BRIEF DESCRIPTION OF REQUEST
Afra Construction, on behalf of West Mesa RV Park formerly known as Paradise RV Park, request Final Sign Off for Site Development Plan approved by EPC

REFERENCE: WEST MESA PARK – FORMERLY KNOW AS PARADISE RV PARK
PROJECT NO: 1008330 / EPC-40073 PHASE II. AND PROJECT NUMBER PR-2024-010907- DFT APPLICATION NUMBER SI-2024-01331.

Based on the NOTICE OF DECISION and recent comments from the DFT staff, we have addressed all the Conditions of Approval in **bold text** as follows:

1 RV CENTERLINE TURNING RADIUS
SP-2 N.T.S TEMPLATE

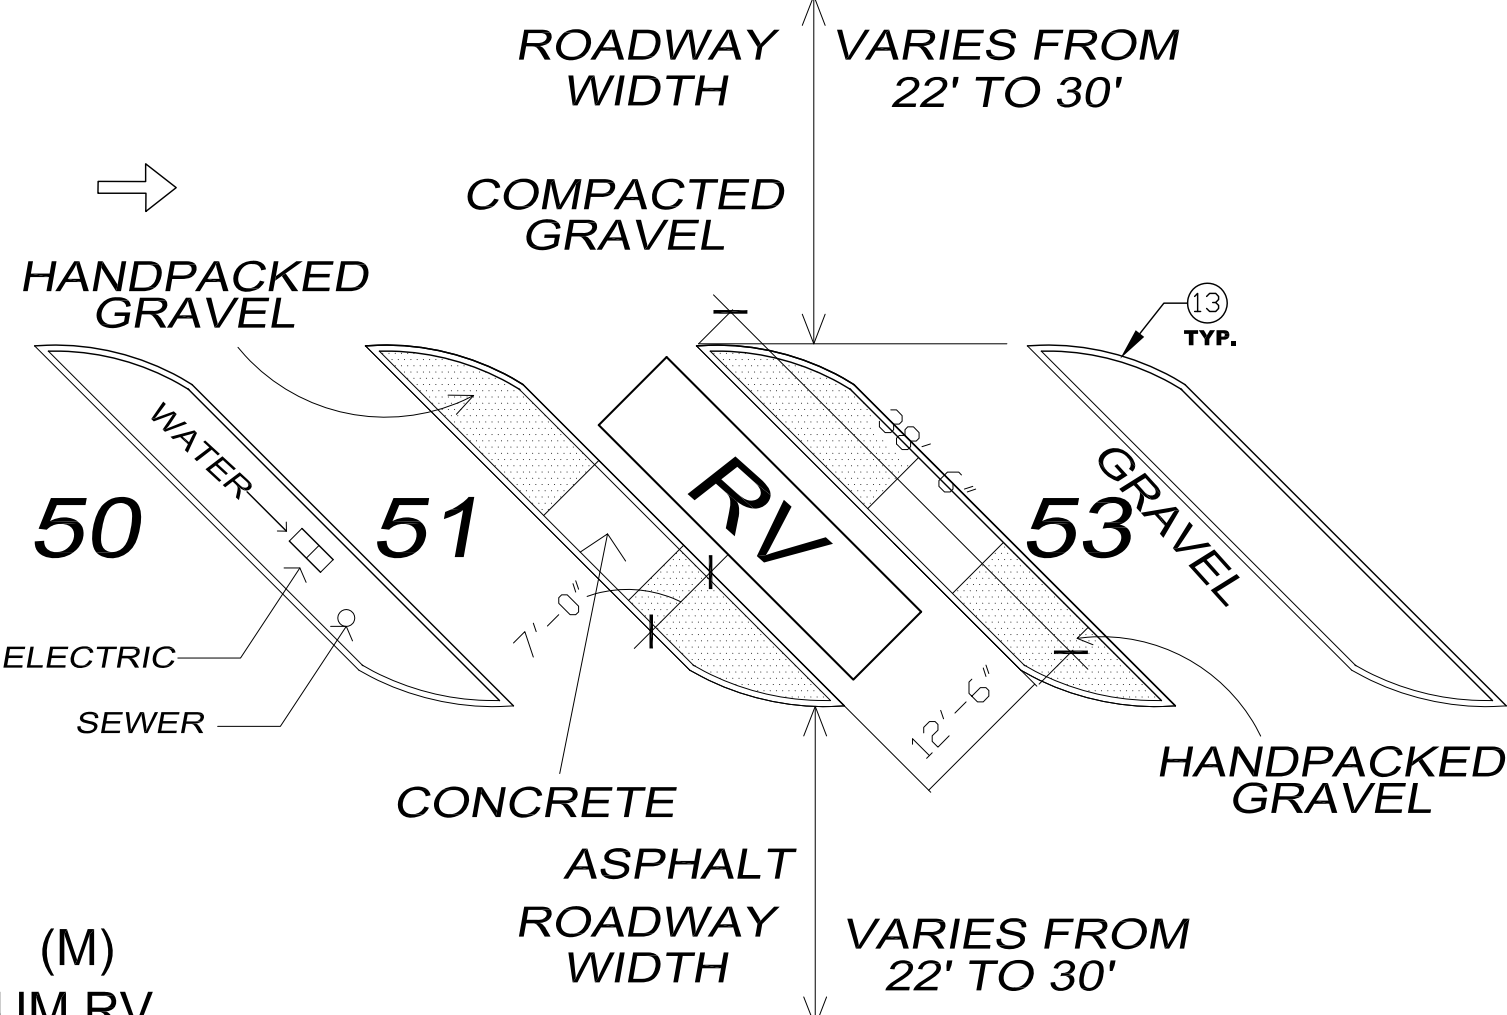
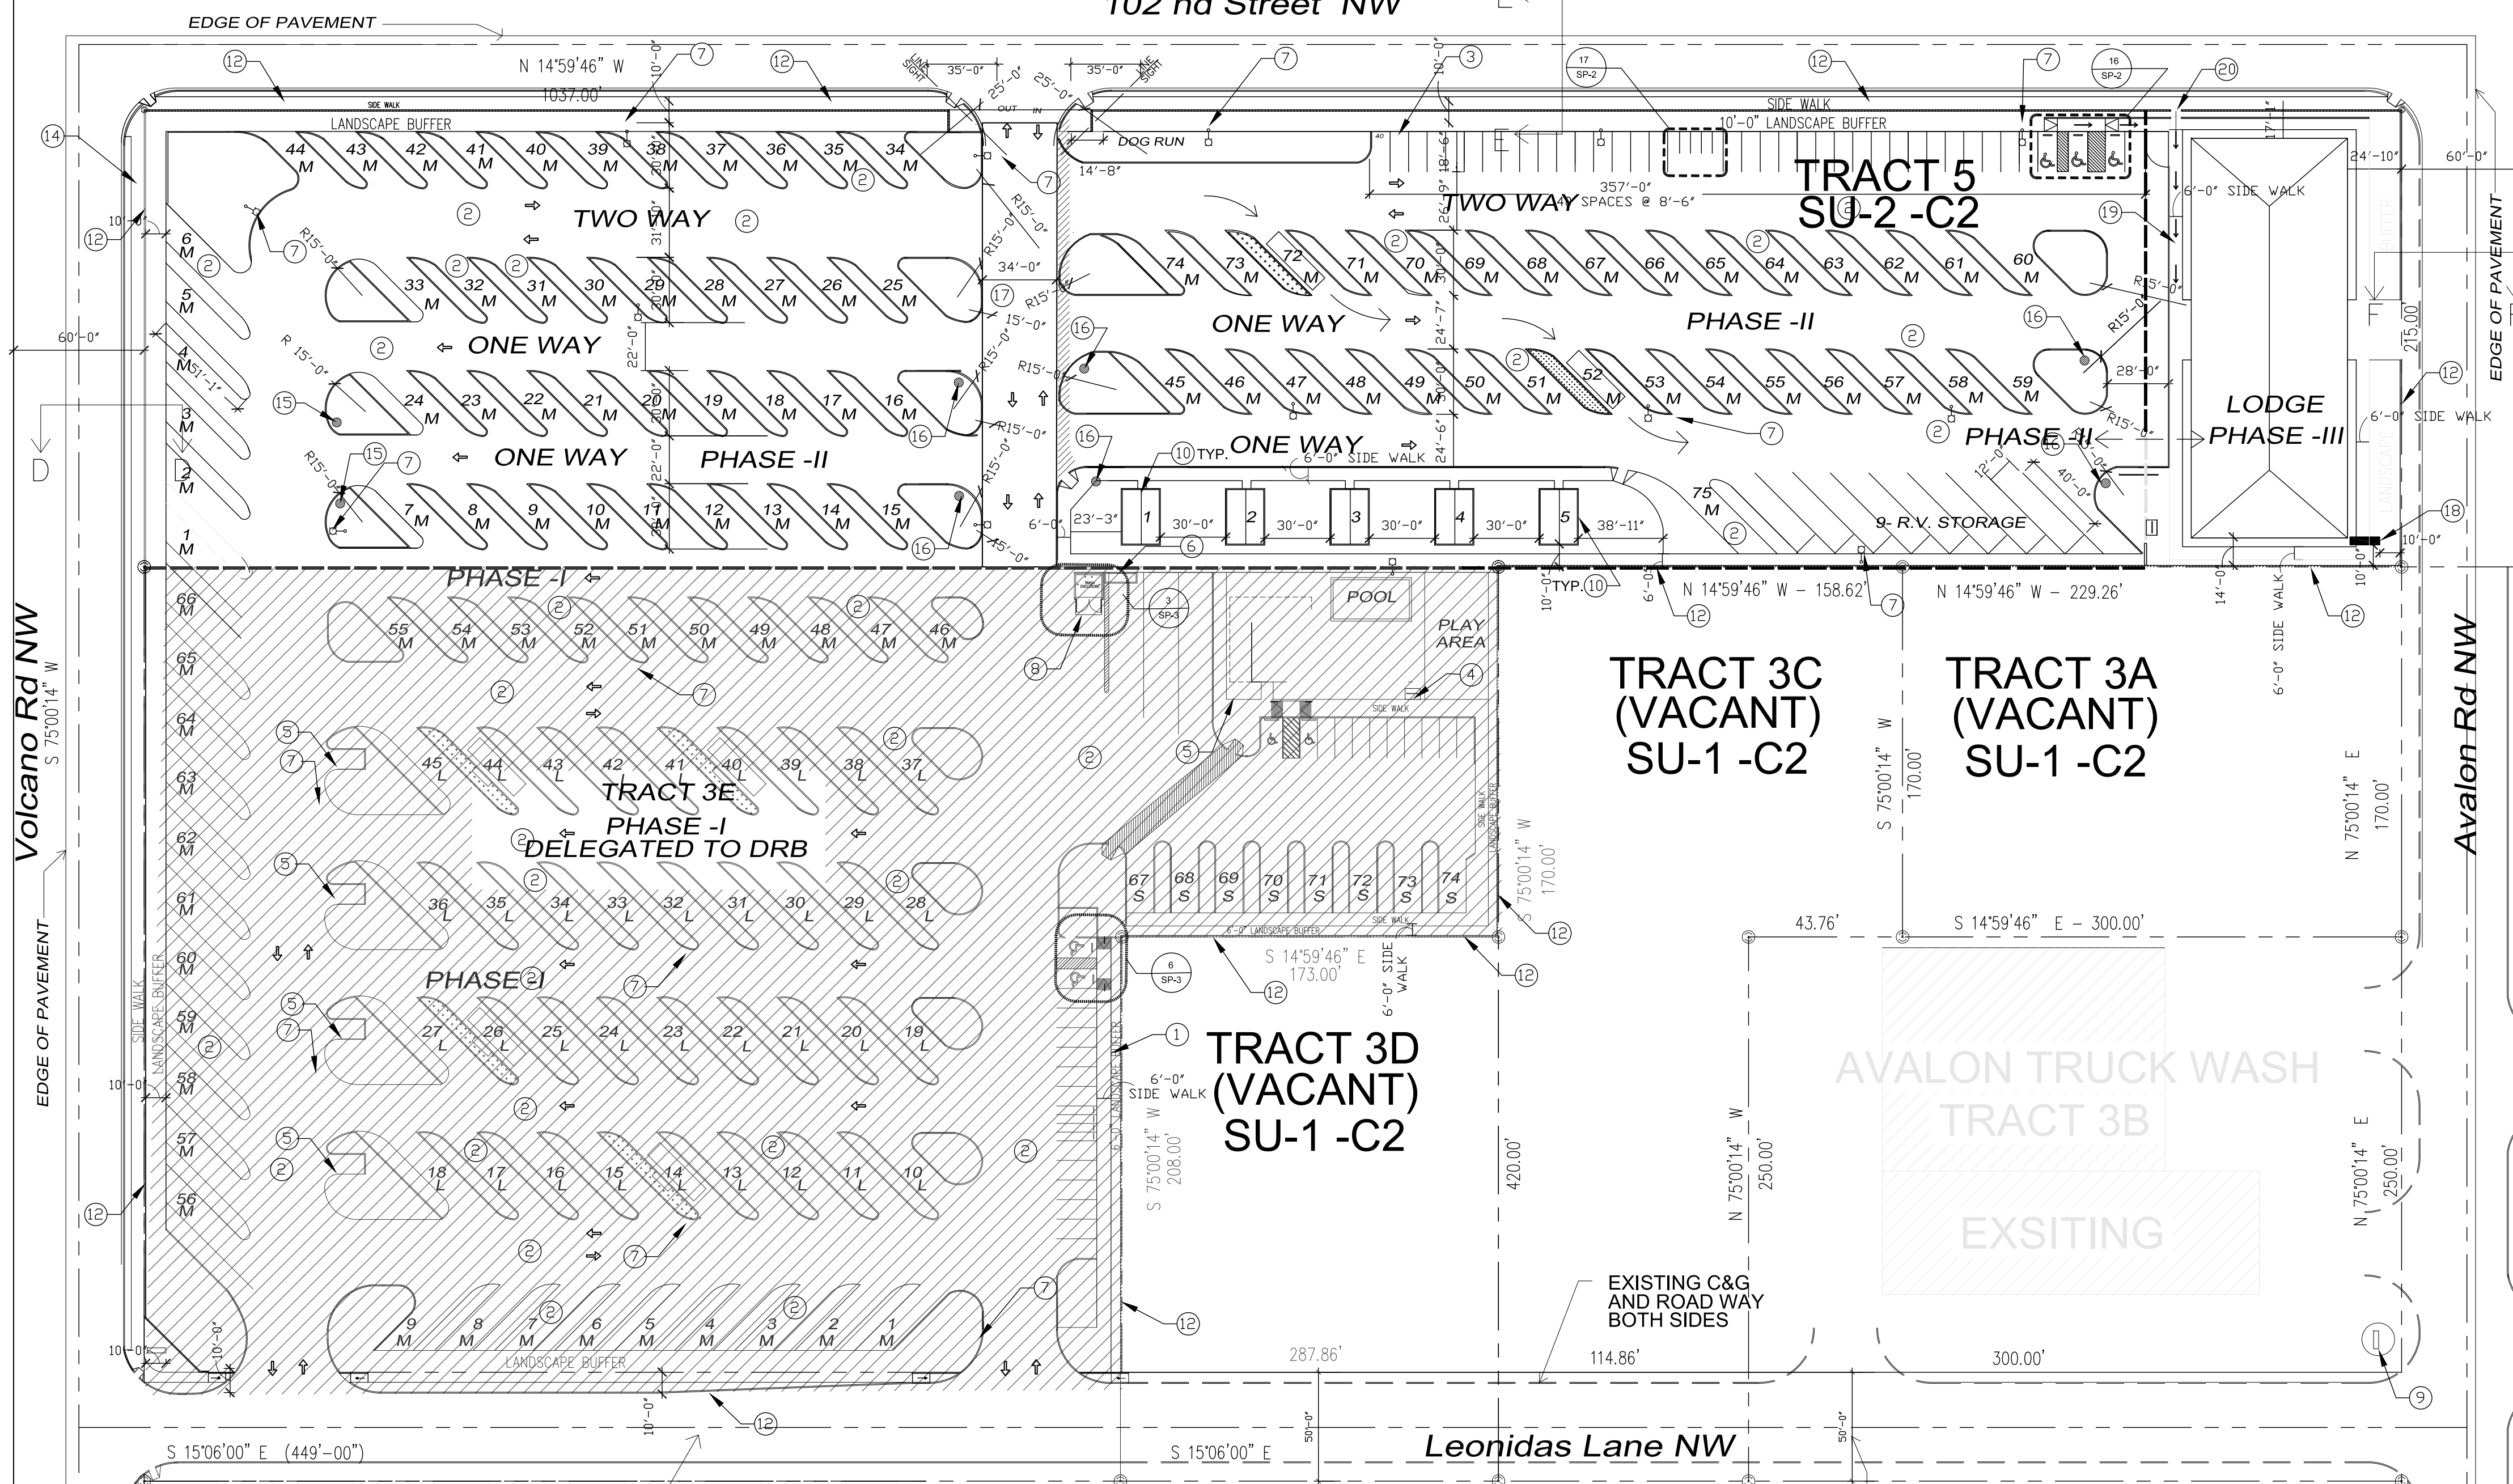
- b. Show/provide turning templates and routes for proposed RV's.

- g. Leonidas Lane is shown as a public right of way on the site plan; however, as-built information indicates that this is a private access easement. Please revise the notation and provide the recording information.

The RV Centerline Turning Radius Template and Routes of the proposed RV's are Shown on SP-1 and SP-2

Recording Information: Document No: 1998126535 shown on Sheet SP-2

SP-3
MARCH / 2024

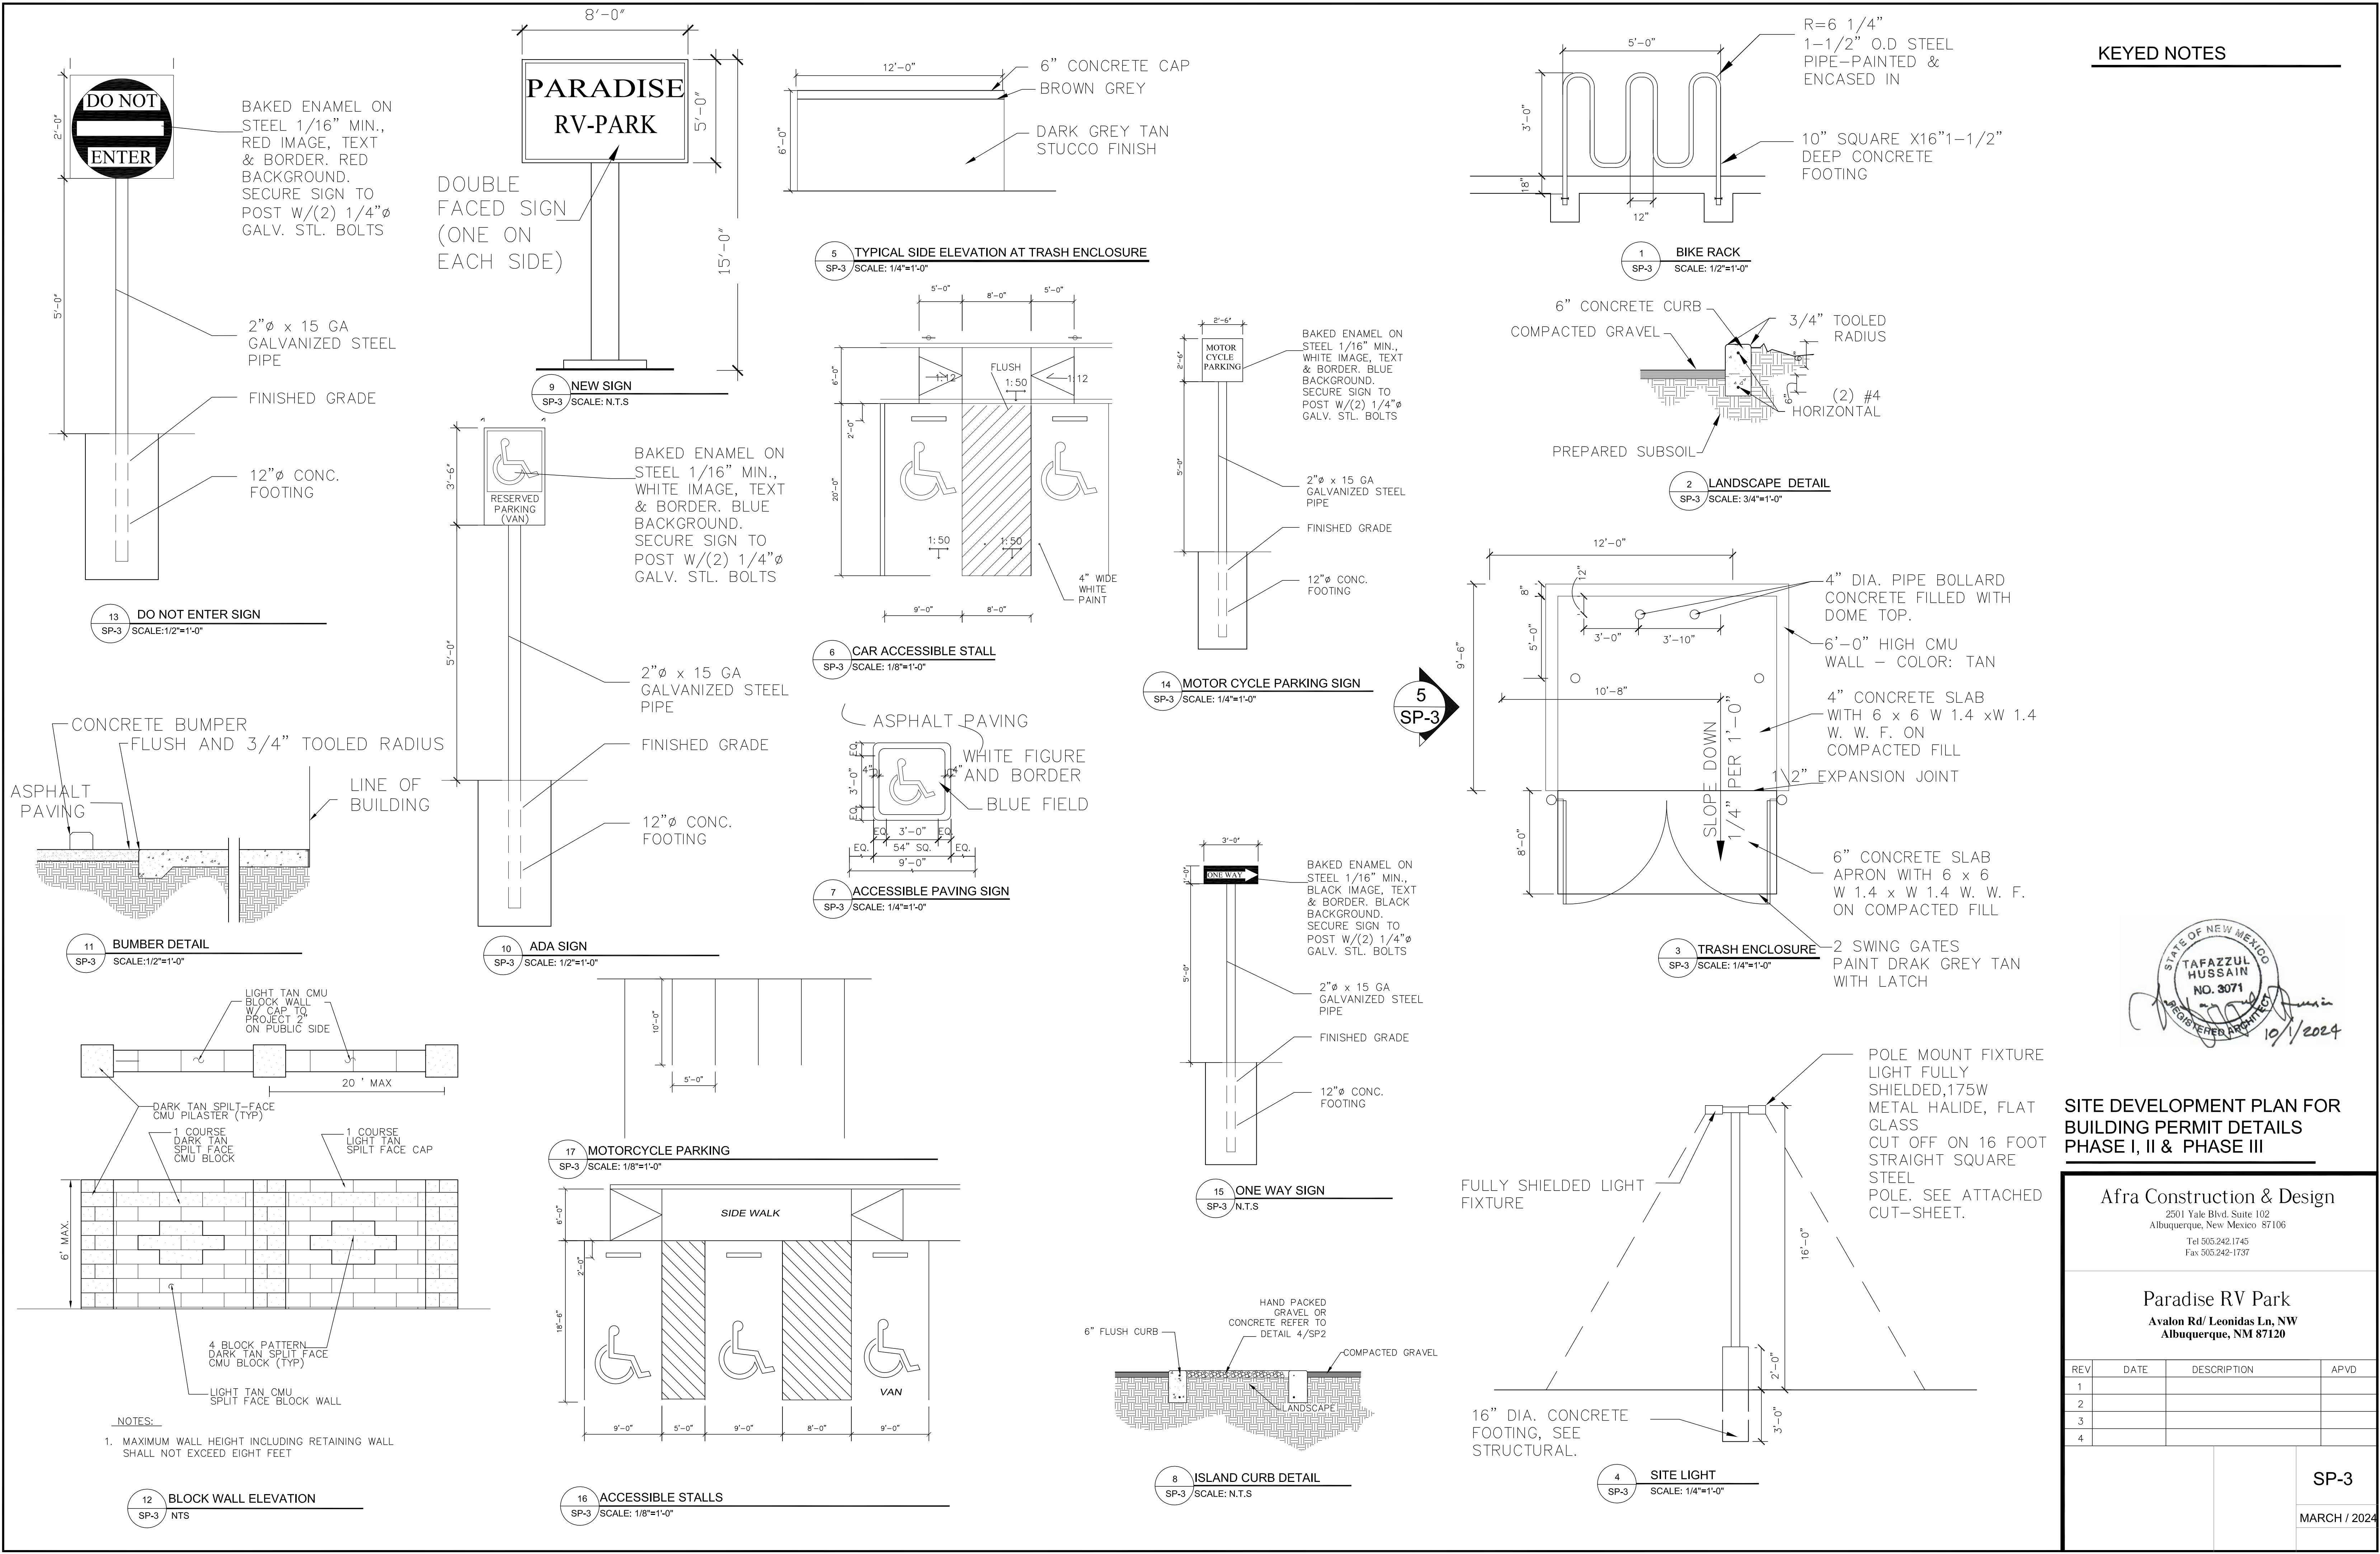
3. The motorcycle and one-way signage shall be shown on the detail sheet.

7. The site plan shall have a note stating whether the two pole-mounted signs have one face or two.

- d. Show the 6-foot wide, ADA accessible, pathway from the ADA parking stalls to the building.

Please refer to sheet no SP-3 – Note No 14 “MOTOR CYCLE PARKING SIGN”.

The two pole mounted Sign shall be Double Faced as shown on Sheet SP-3.

ADA accessible Pathway is shown on Sheet SP-3
